From: Sian Eggington [REDACTED]
Sent: 24 January 2020 [REDACTED]
To: Sian Eggington
Subject: FW: Further Information Required on Your Ref: PP-08424788 Our Ref: EP/7/20/HH
Attachments: 06 Proposed block plan Rev A.pdf

From: Matt Bridle <[REDACTED]>
Sent: 23 January 2020 [REDACTED]
To: Planning.Responses [REDACTED]
Subject: RE: Further Information Required on Your Ref: PP-08424788 Our Ref: EP/7/20/HH

Revision: A		Jan 20	Boundary distance added	
address		Ashfield, South Strand, East Preston, BN16 1PN		
project		Proposed Extension		
title		Proposed Block Plan		
scale	date	dwg no.	revision	
1:500 on A3	Jan 2020	2019.263.06	A

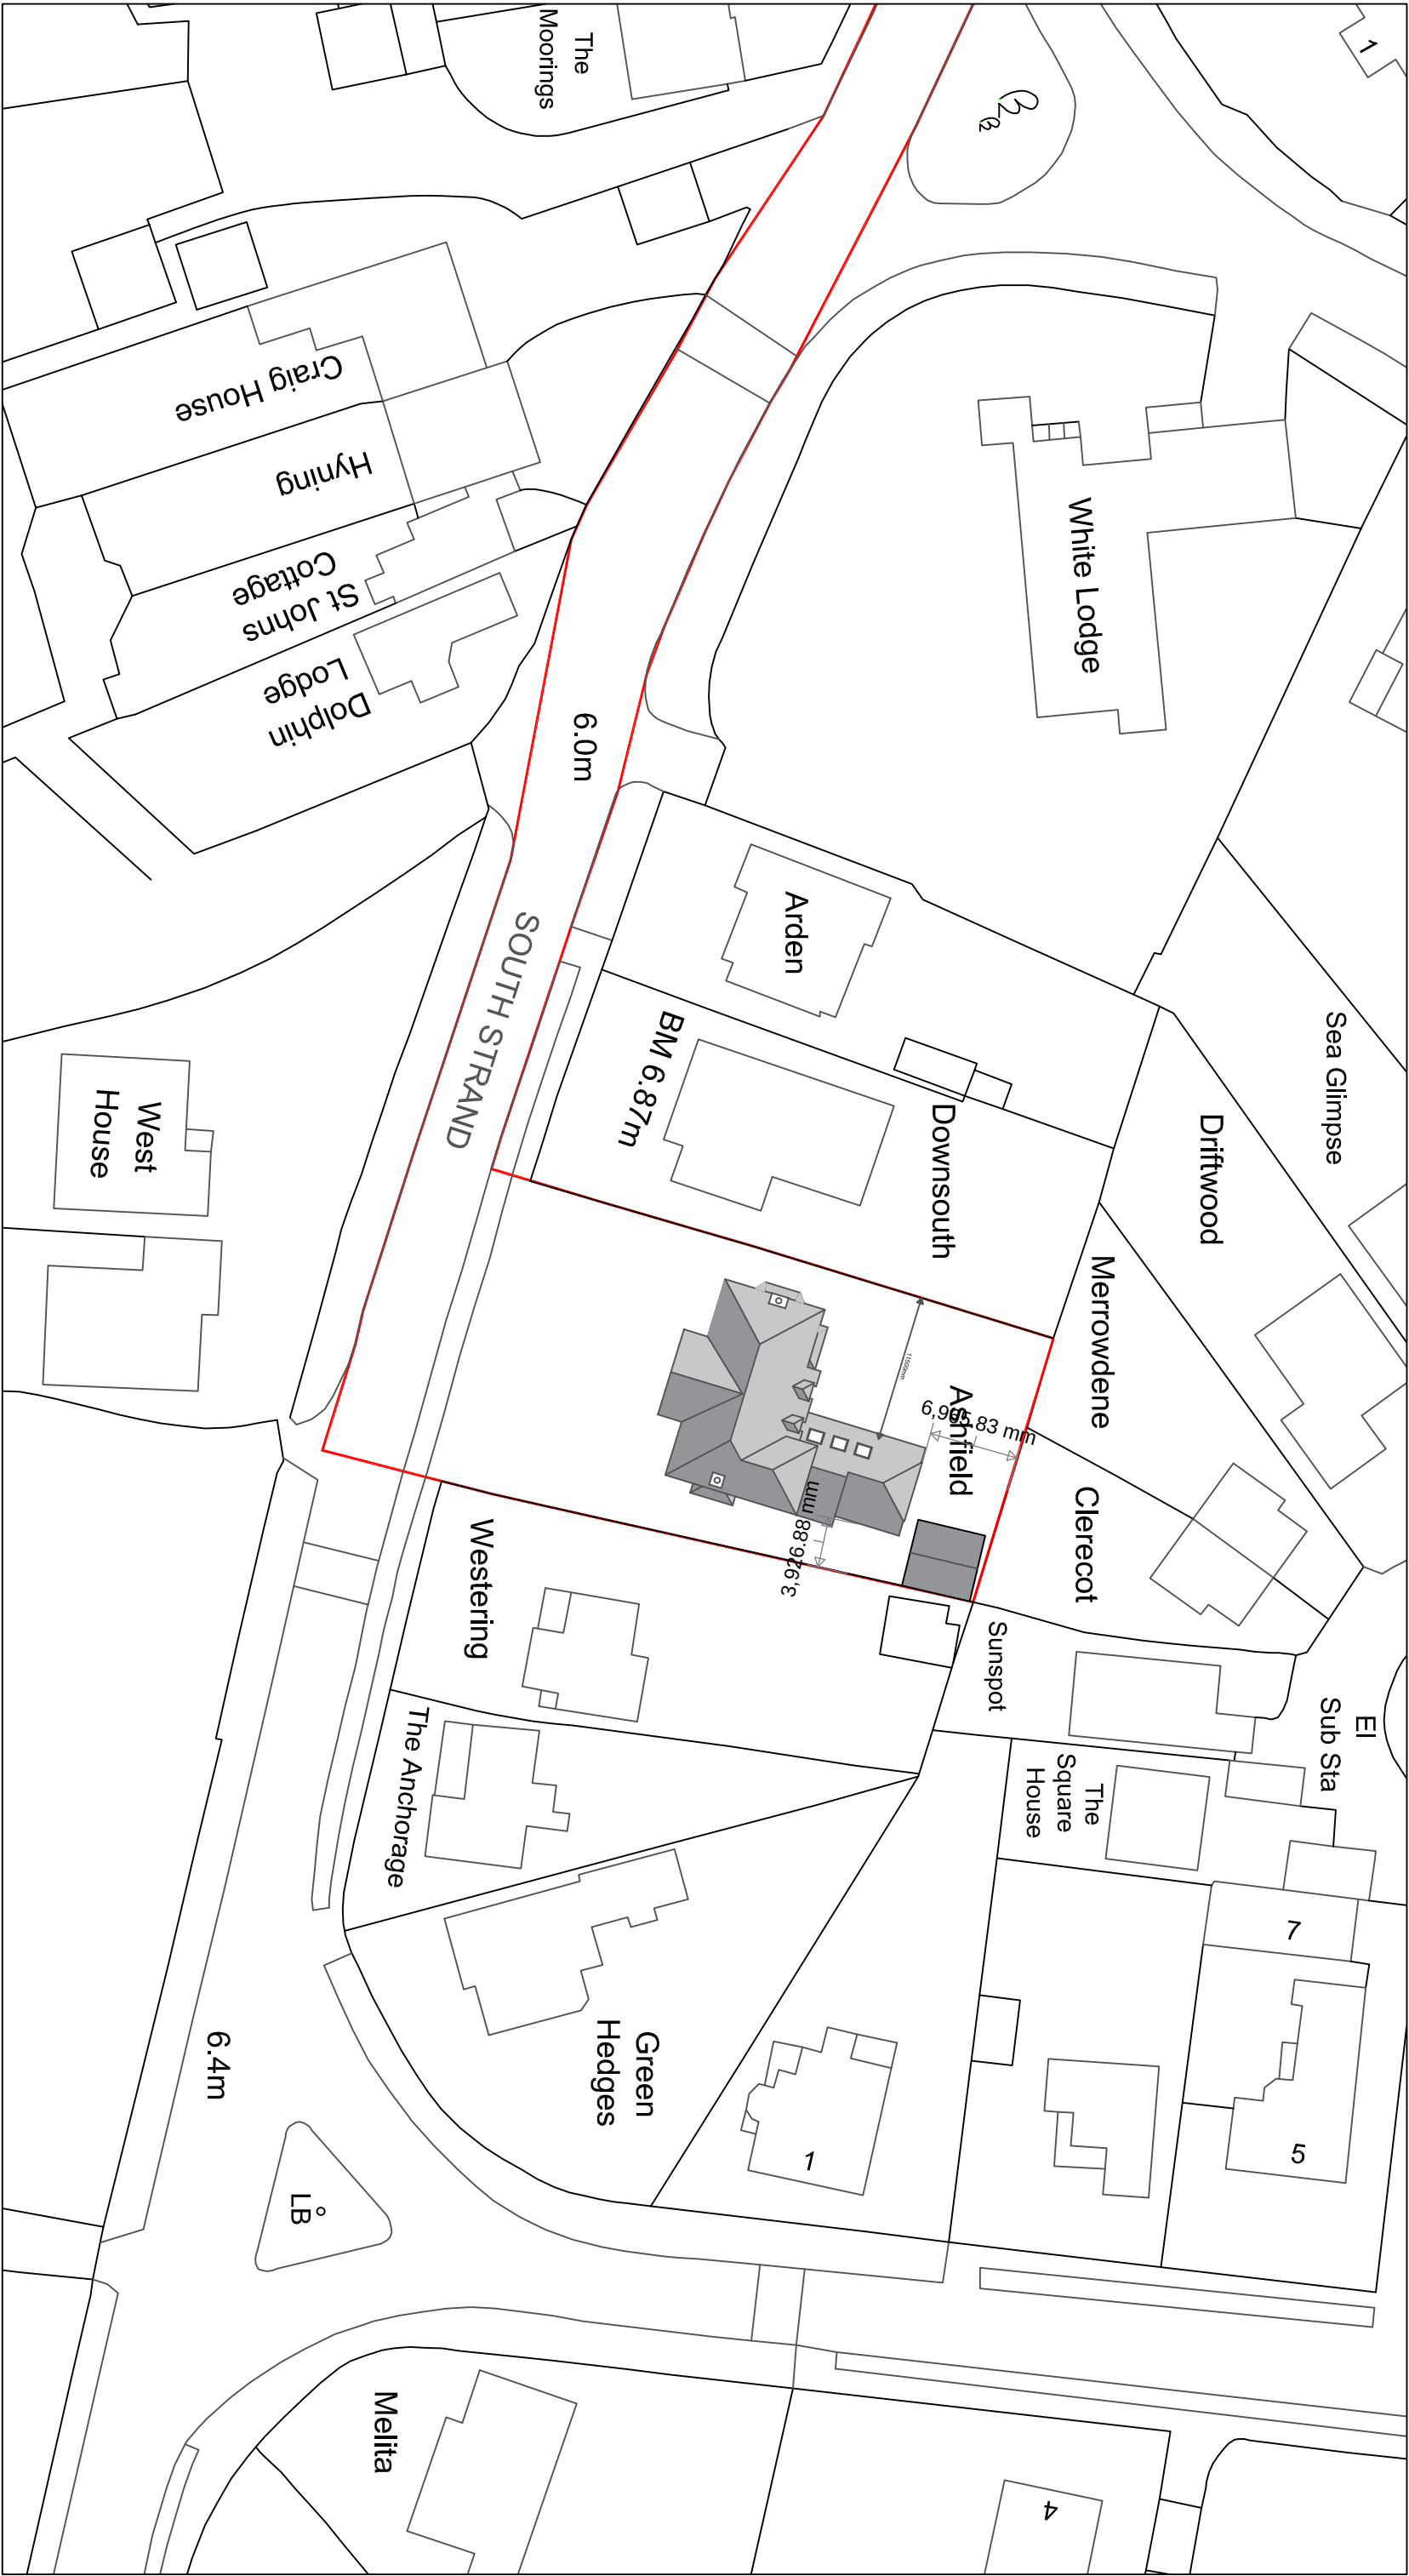
2) Please find enclosed the attached block plan showing the distance to the nearest boundary as requested.
